Ask for:	Erika Davies
Telephone:	01832 742207
Planning Services	Planning.ENC@northnorthants.gov.uk
Our Ref:	NE/21/00969/FUL
Your Ref:	PP-09945176
Date:	23 June 2021

Proposal : **Single storey rear extension; first floor extension to create an additional bedroom and addition of front canopy at Manorfields Caldecott Chelveston Wellingborough Northamptonshire NN9 6AR .**

I refer to the above application received on **16 June 2021** but have to advise you that it is **INVALID/INCOMPLETE**. In order to enable further progress to be made, please supply the following:

PROPOSED PLANS

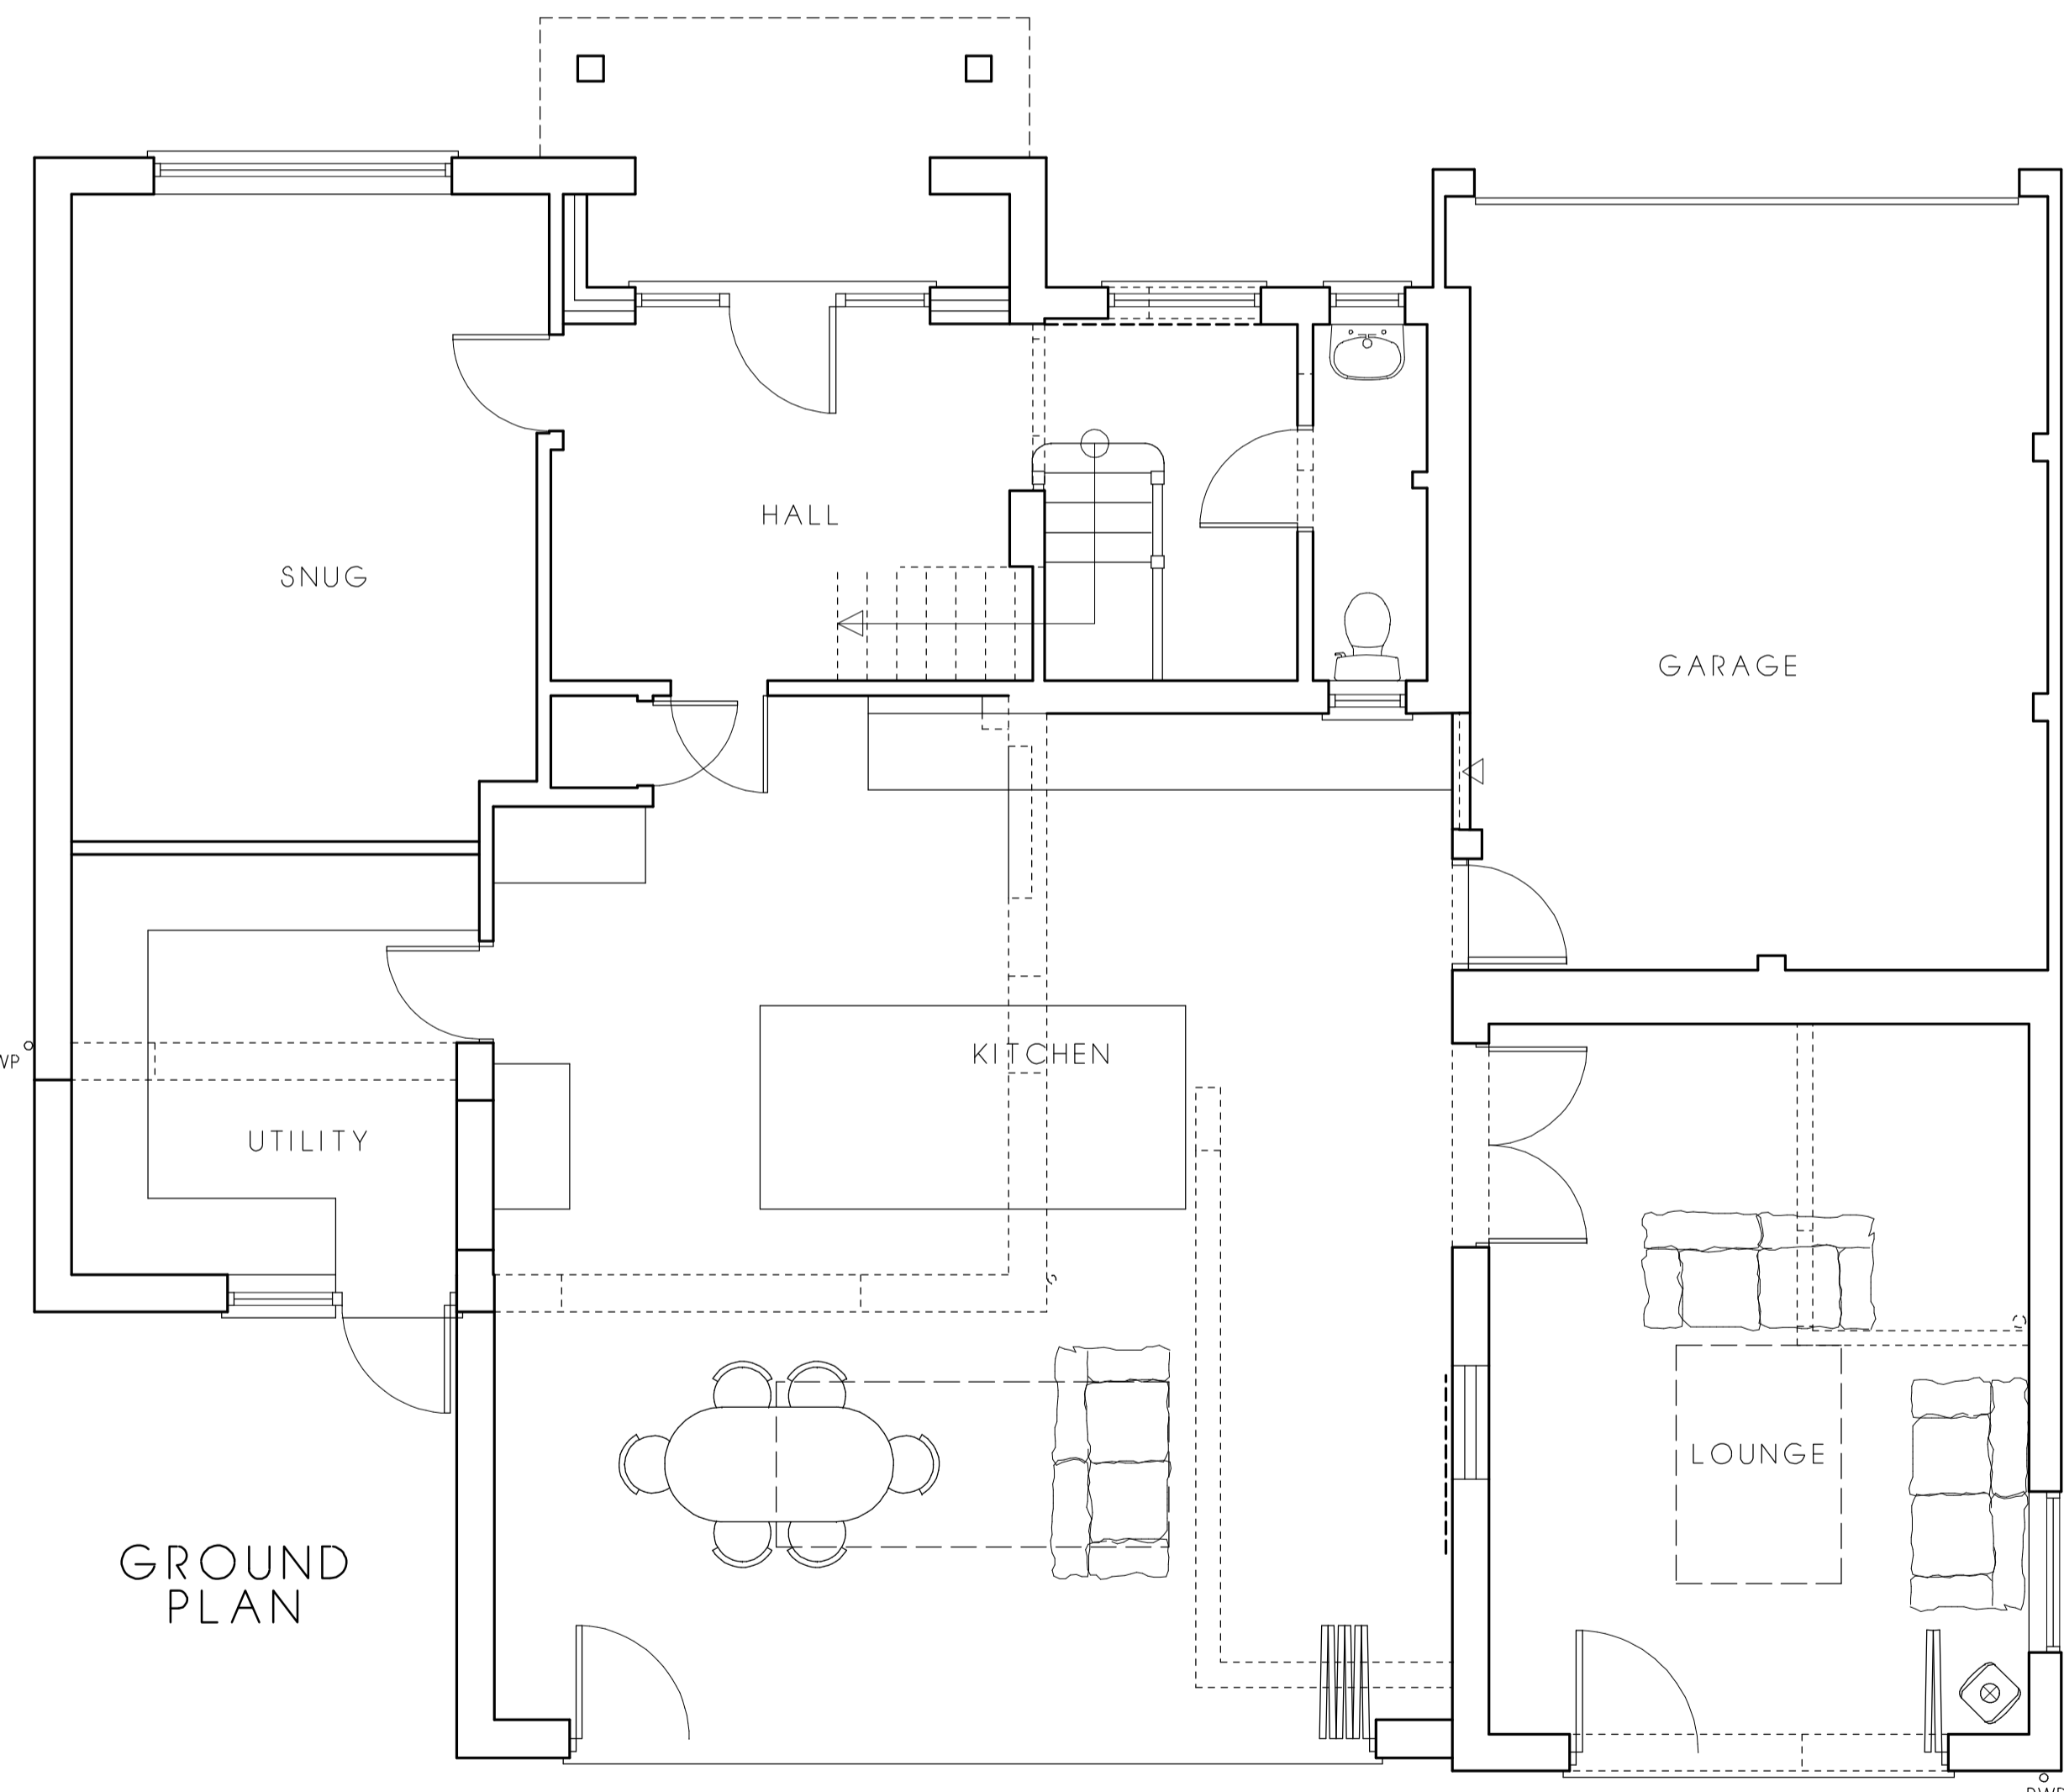
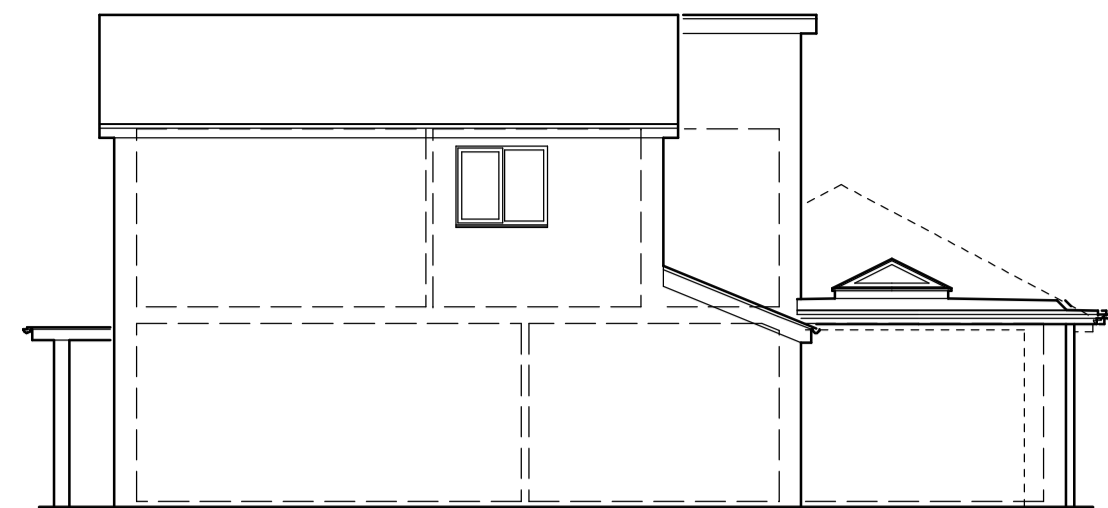
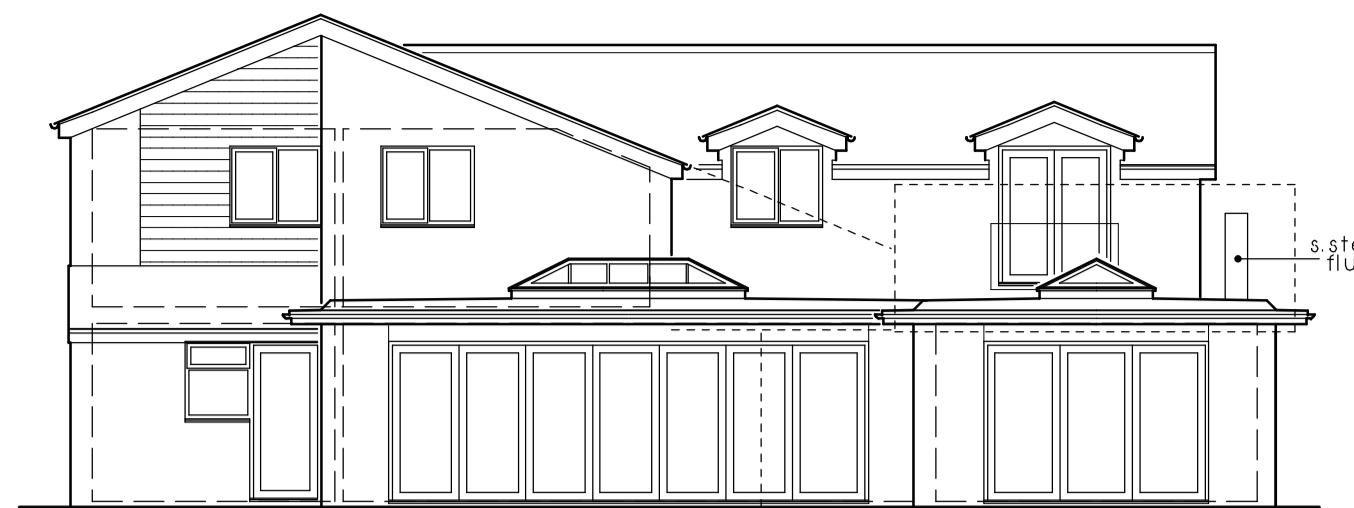
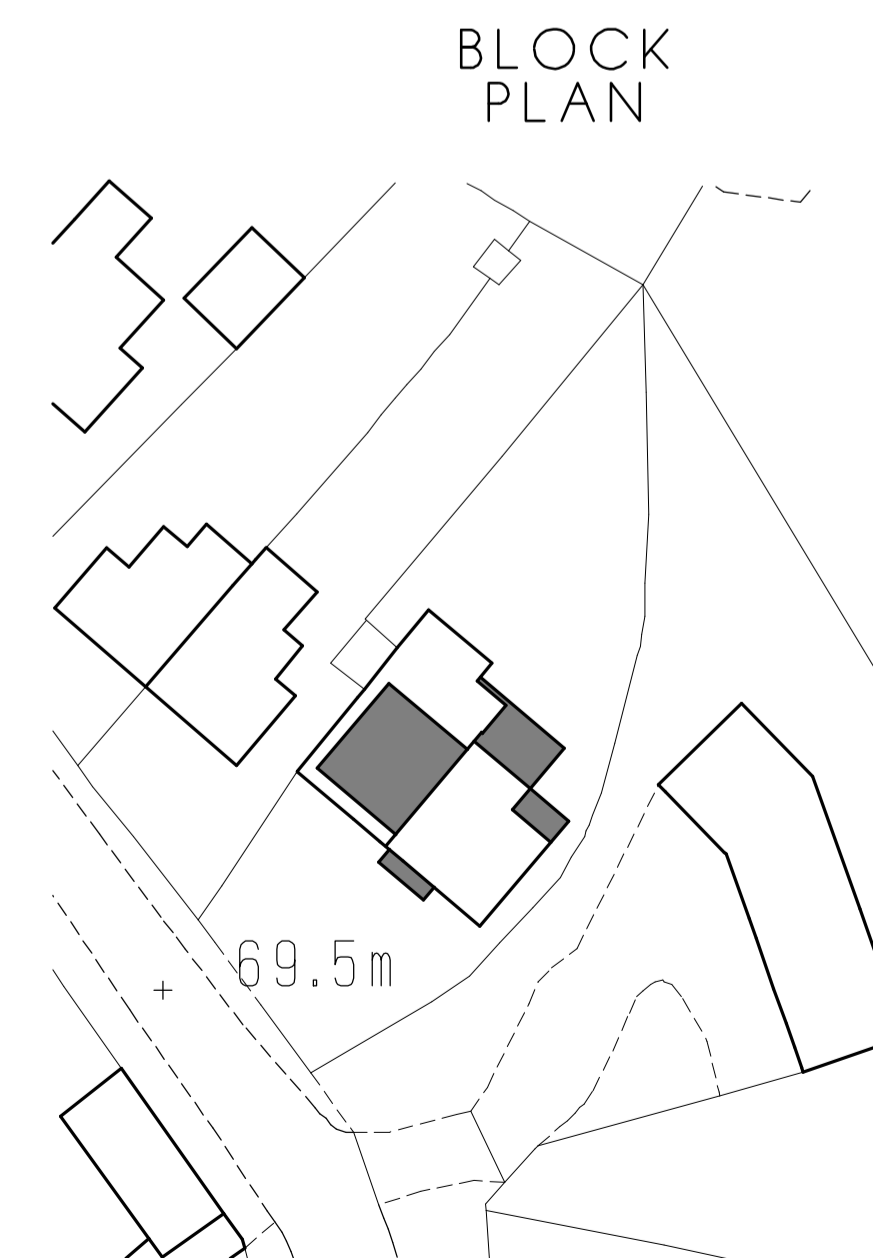
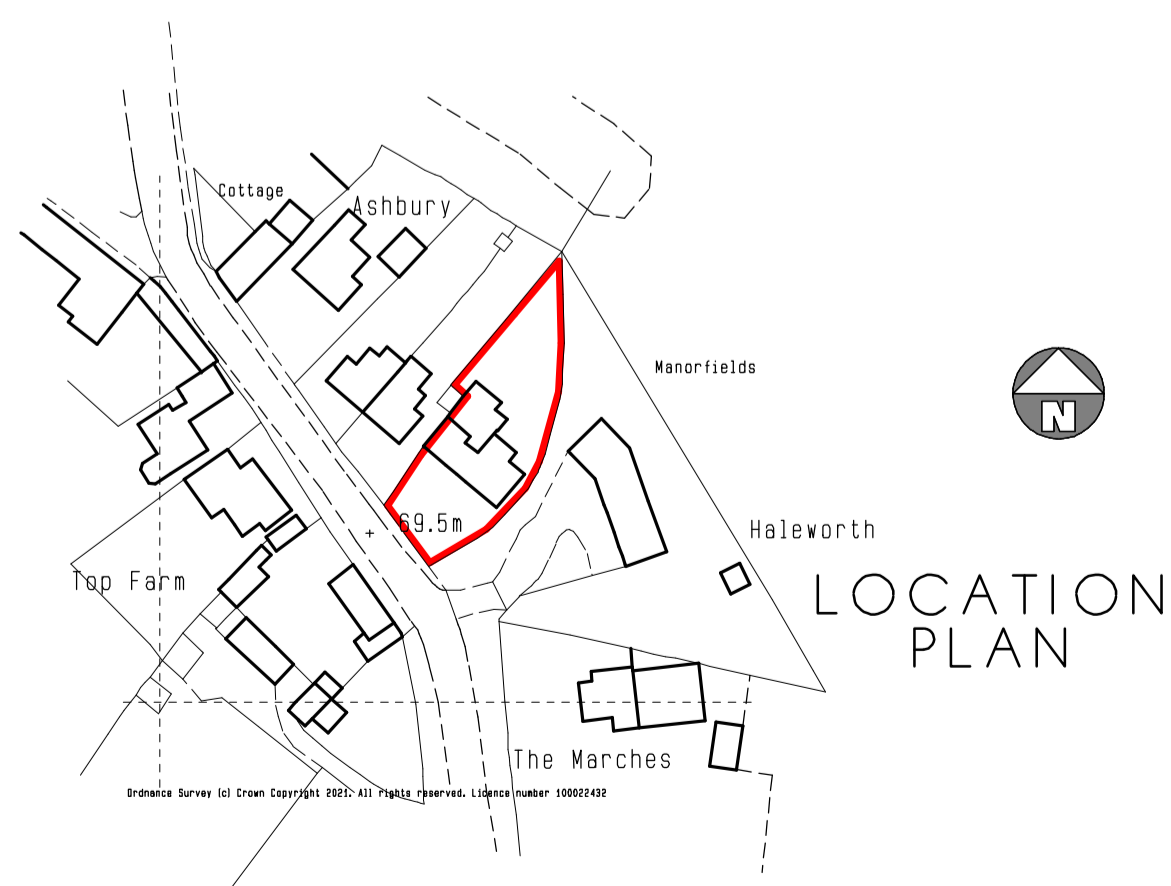
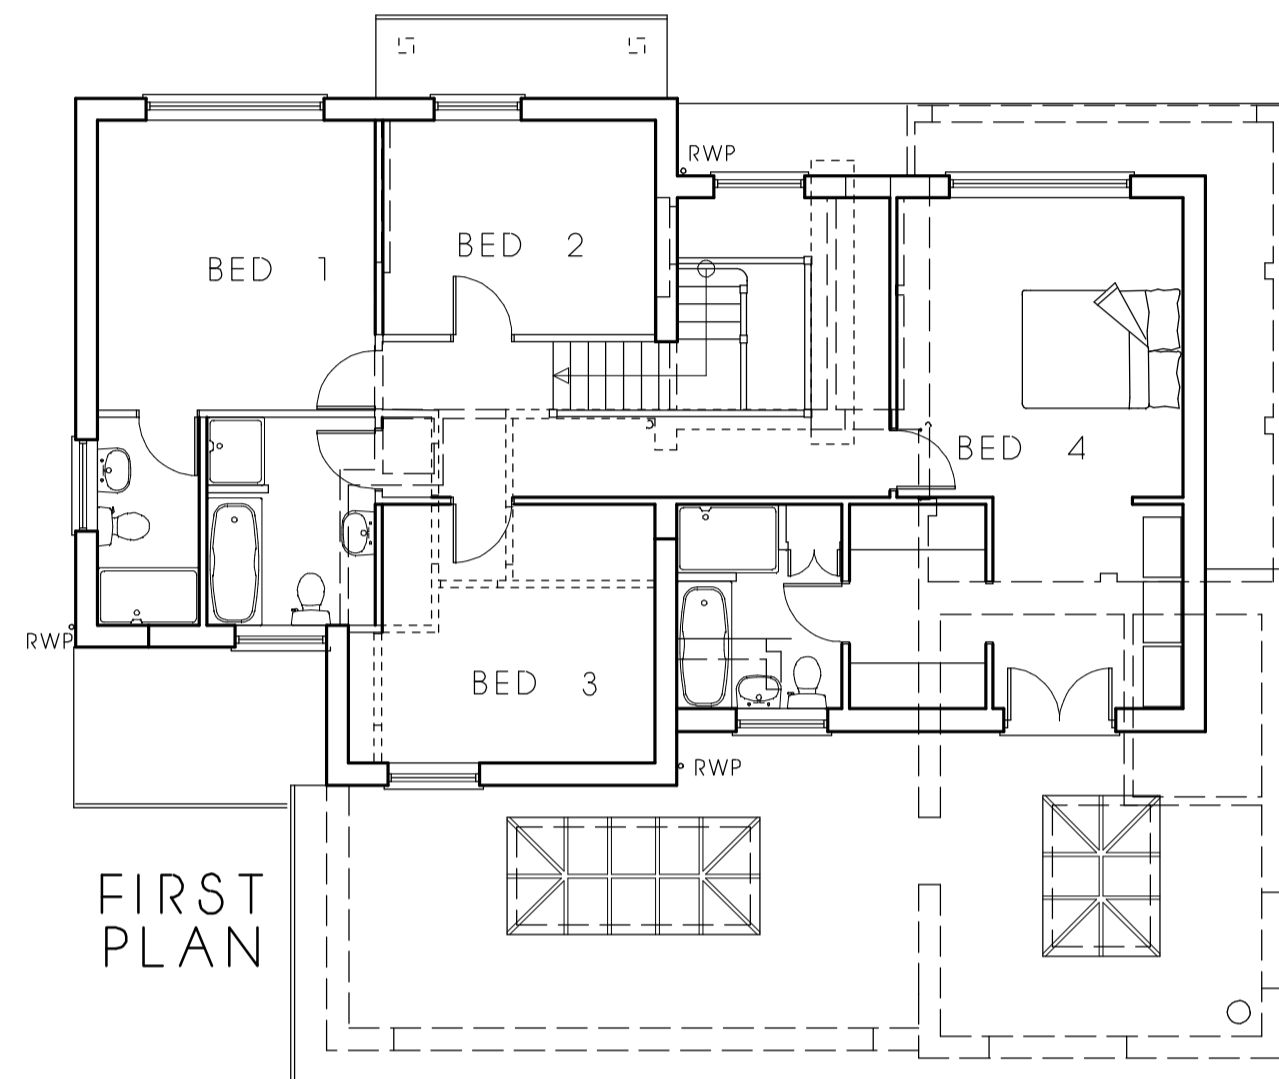
2. As per our Published Local Requirements the site plan (1:500) should include your proposals for on-site access and parking. Please provide an amended site plan showing your proposals for car parking.

3. Thank you for the drawings submitted with your application, even though the scale used has been given no dimensions have been provided, additionally the existing elevations appear to be mislabelled and do not match the proposed elevations with two of the existing elevations identified as "South- West Elevation". As per our published Local Requirements, "All plans and drawings must be drawn to an appropriate metric scale (1:50 or 1:100) and have all relevant dimensions of the key elements of the proposal clearly written. This includes the height, length, width and (if relevant) the distance from the site boundary of any proposed works. We

Please provide amended drawings including all relevant dimensions of the proposal:

- Dimensions for the existing and proposed floor plan;
- Dimensions for the existing and proposed elevations annotated with all height dimensions and clearly identified;
